From: Paul Cann
Sent: 11 January 2018 13:20
To: Planning.Responses
Subject: RE: Planning Consultation on: EG/100/17/HH

APPLICATION EG/100/17/HH

Site Address: 4 Wentworth Close Barnham PO22 0HS

Description of Works: Single storey rear extension - Resubmission of EG/59/17/HH

block plan
1 : 500

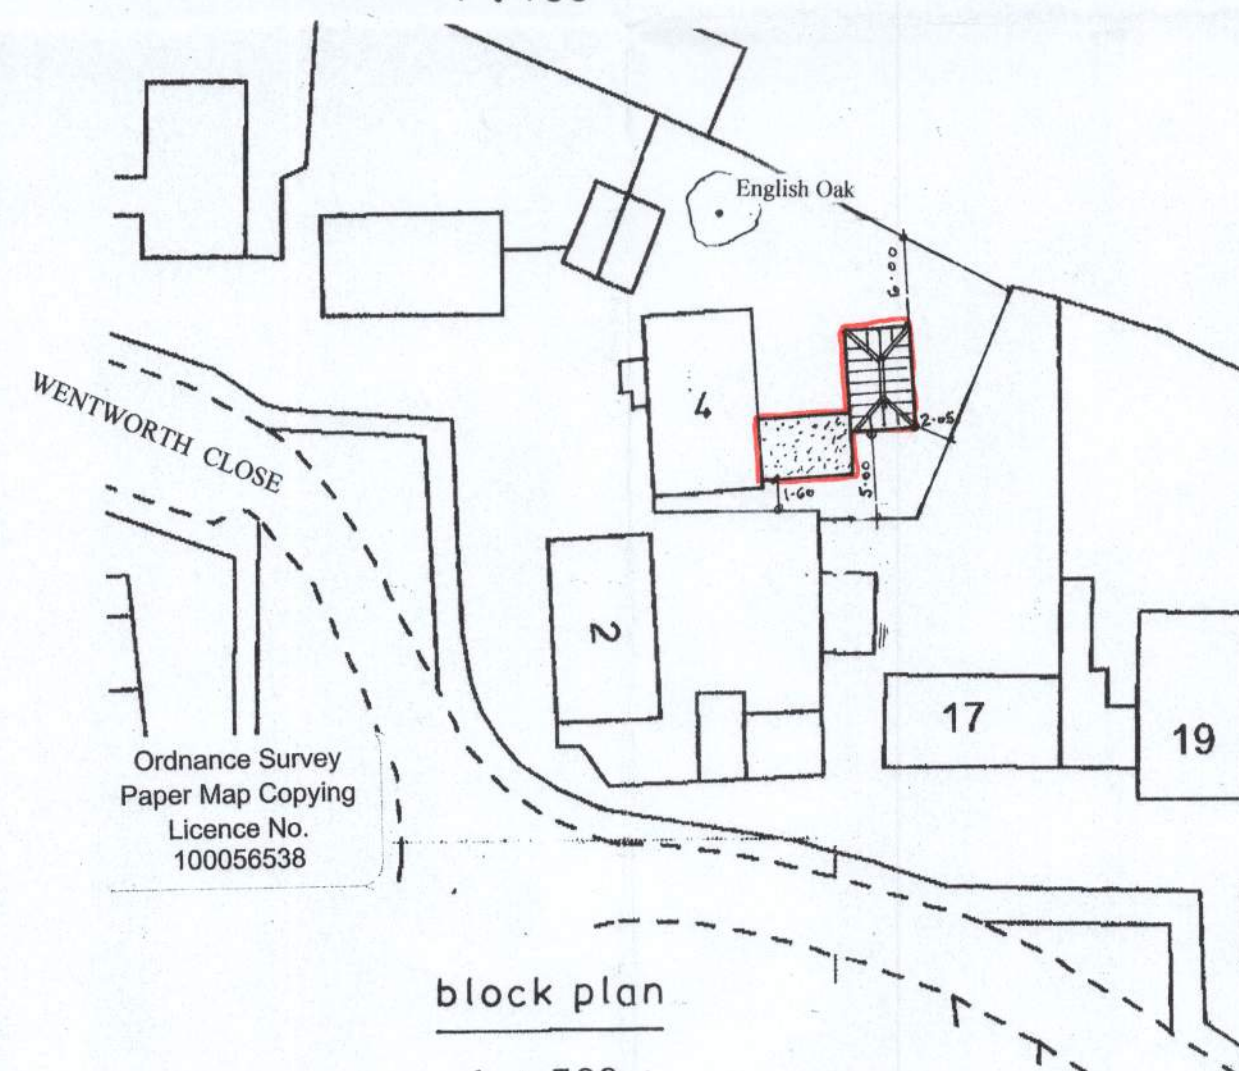
A culvert is believed to pass through the rear garden of the property. It is essential that its location/existence is confirmed by the applicant, so further discussion can be had. Any new building will need to be kept at least 3 metres from the edge of the culvert unless otherwise agreed.
